**From:** Contact Centre (CRM) <contact@ribblevalley.gov.uk>  
**Sent:** 29 May 2024 17:58  
**To:** Planning  
**Subject:** Planning Application Comments - 3/2024/0029 FS-Case-618503163

**Planning Application Reference No.:** 3/2024/0029

**Address of Development:** 5 The Dene, Hurst Green, Clitheroe. BB7 9QF

**Comments:** This is a formal objection to work currently being carried out, and other proposed work at number 5 The Dene, Hurst Green.

Proposed Site Sections

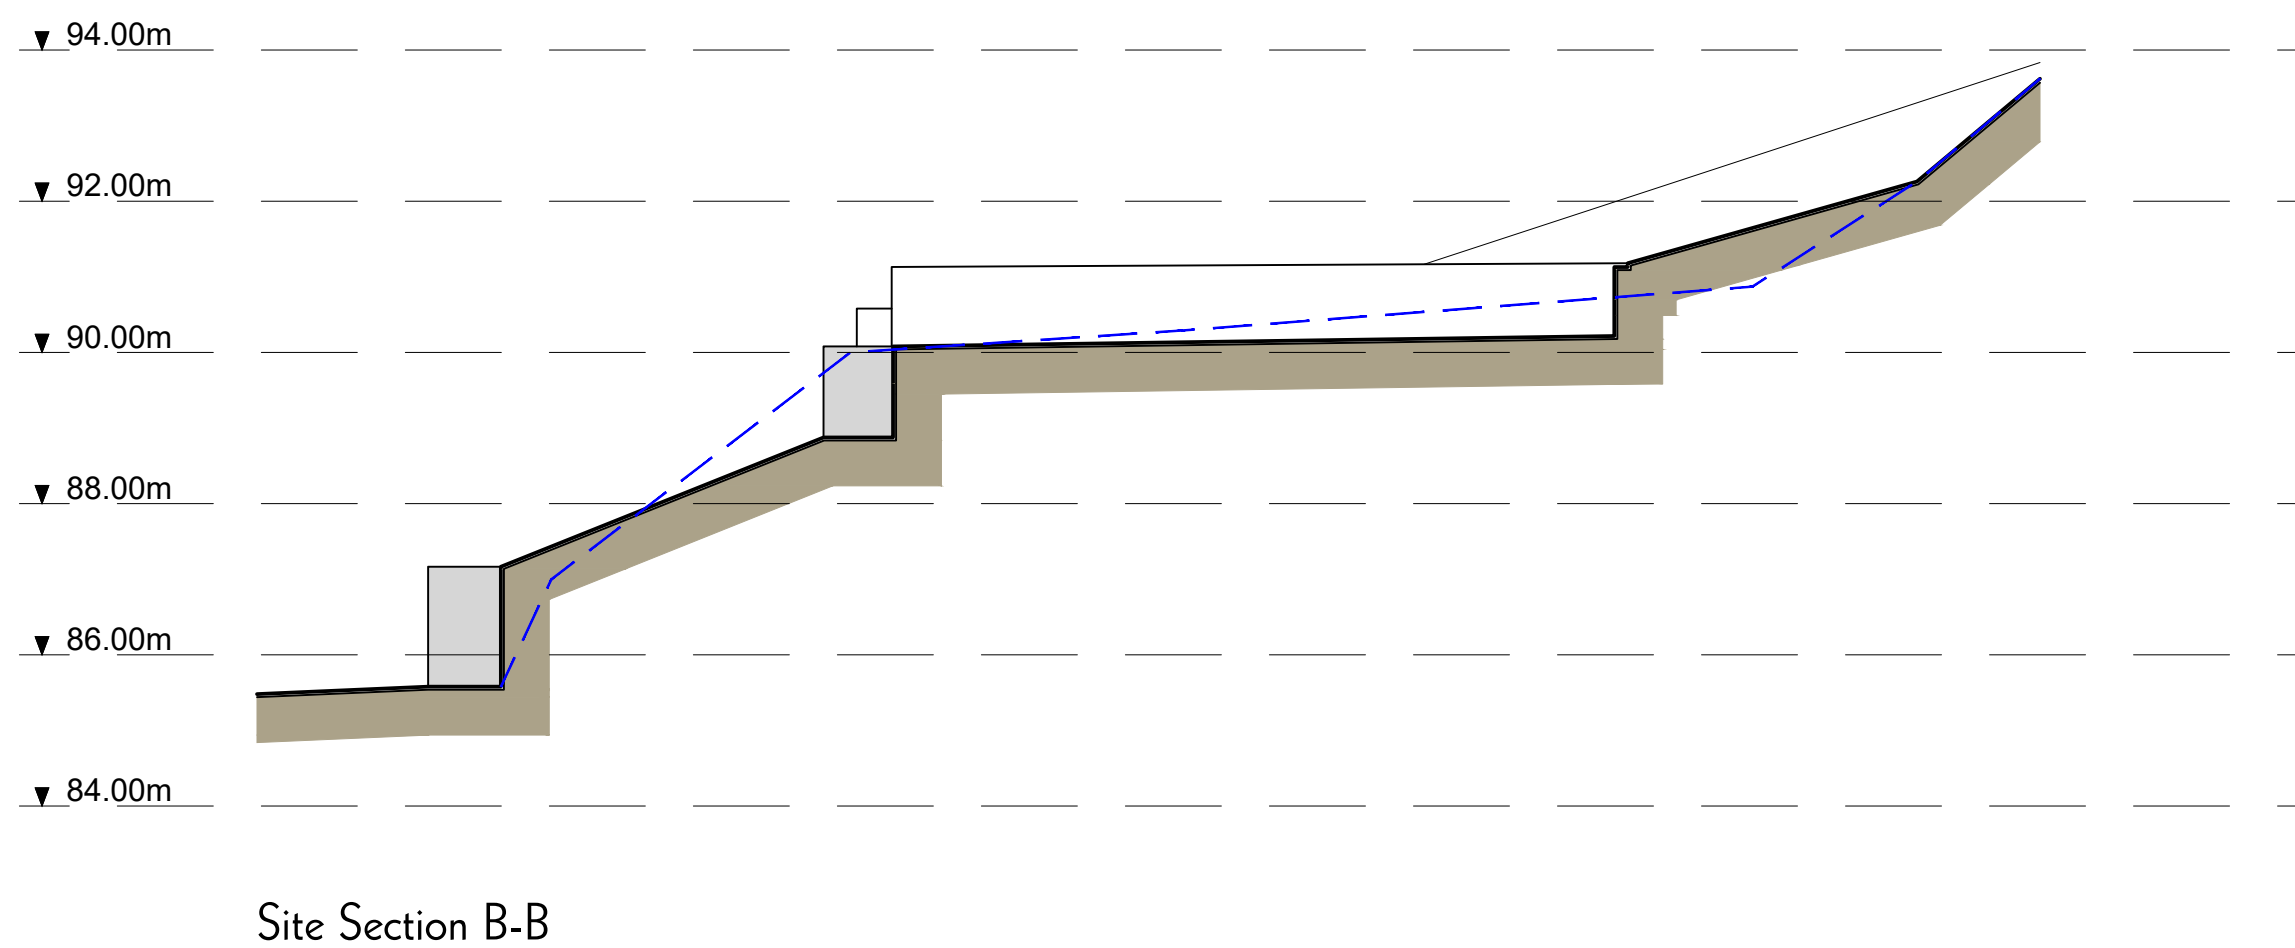
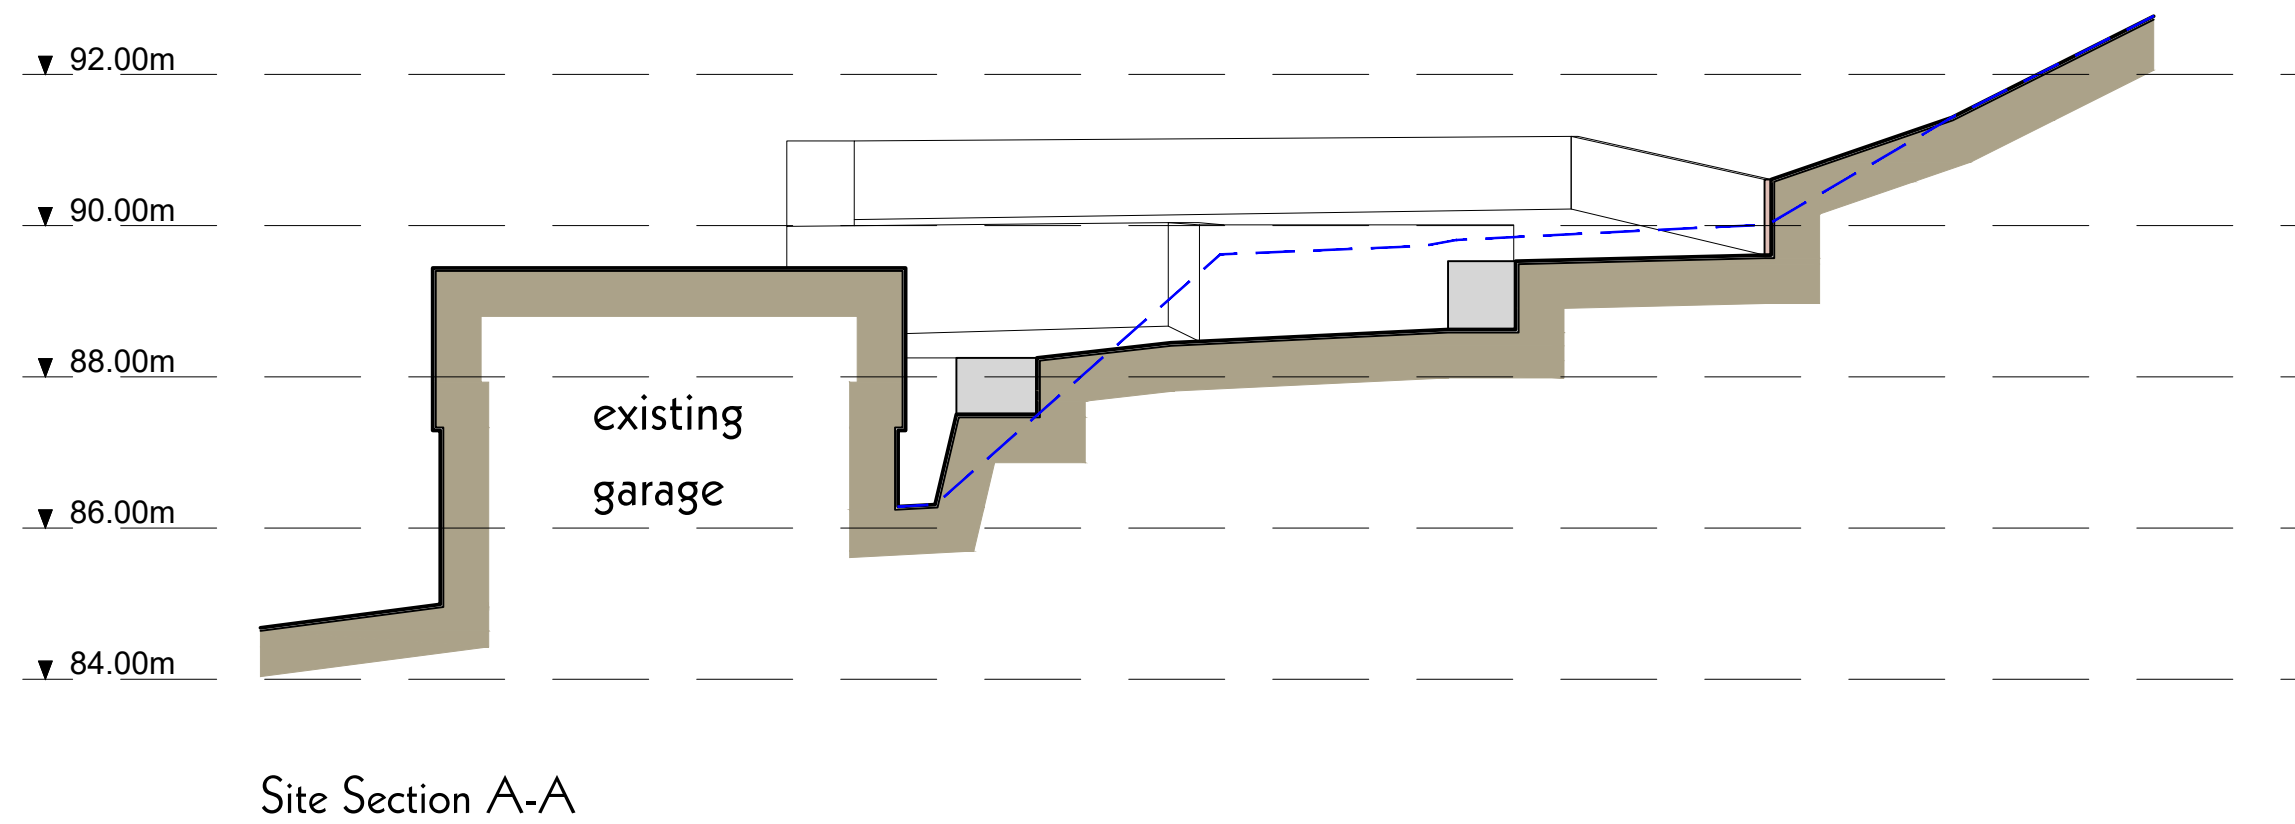
In conclusion ■■■■ would like to see the levels of the gardens to the left of the house reduced back to the original levels and the introduction of trees and shrubs along the bank facing the road to at least offset the loss of the trees taken out, also as a step towards keeping some sort of privacy for both ■■■■■■■■■■ new neighbours at ■■■■■■■■■■ would also like to see the removal of the roof lights/windows facing out towards the road and maybe reciting to face towards their rear garden.

## Proposed Site Layout

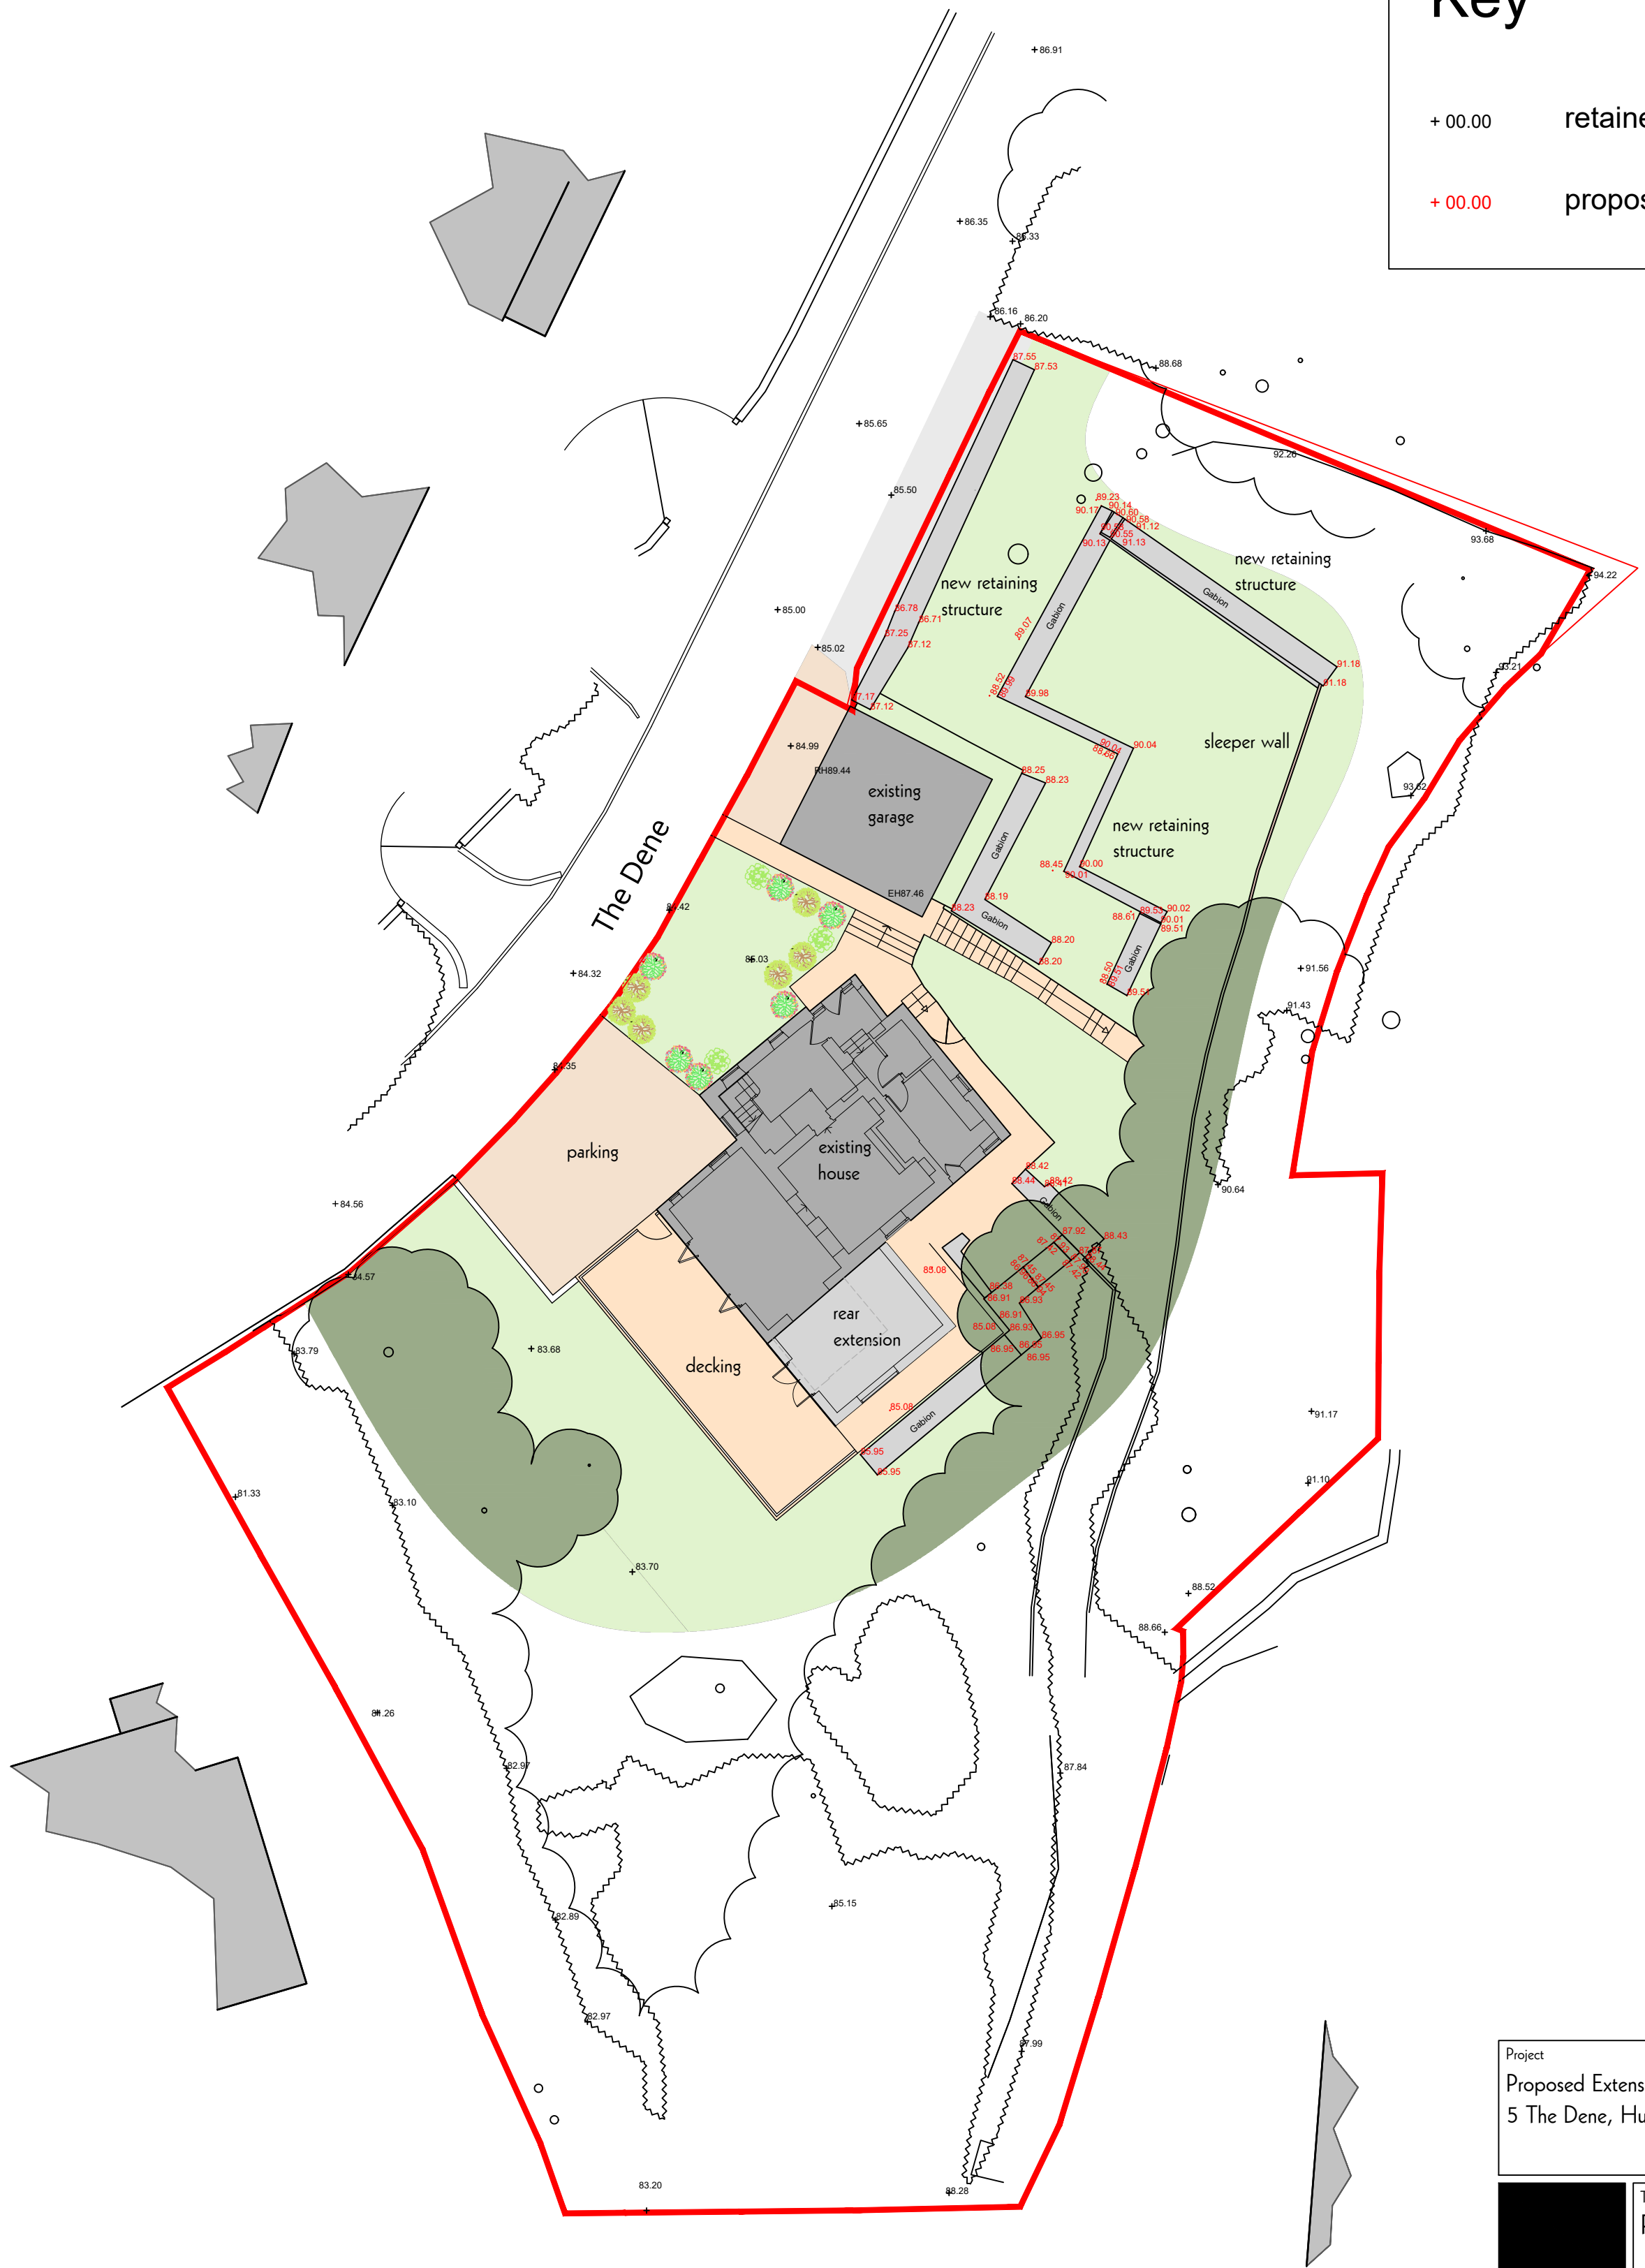
[REDACTED] first objection regards the garden/land and its dramatic change of use and appearance.

Already, before planning permission was formally requested the above site had all of its beautiful gardens cleared, including the removal of many significant trees, (see attached photos) not only this, a driveway has clearly been put in place and much of the land has had significant alterations to its original profile, including raising of levels, especially to the left of the house when viewed from the road. This is now [REDACTED] The harsh landscaping being carried out using gabions filled with stone is not in keeping with the area and gives what [REDACTED] can only describe as an 'industrial' look to the development.
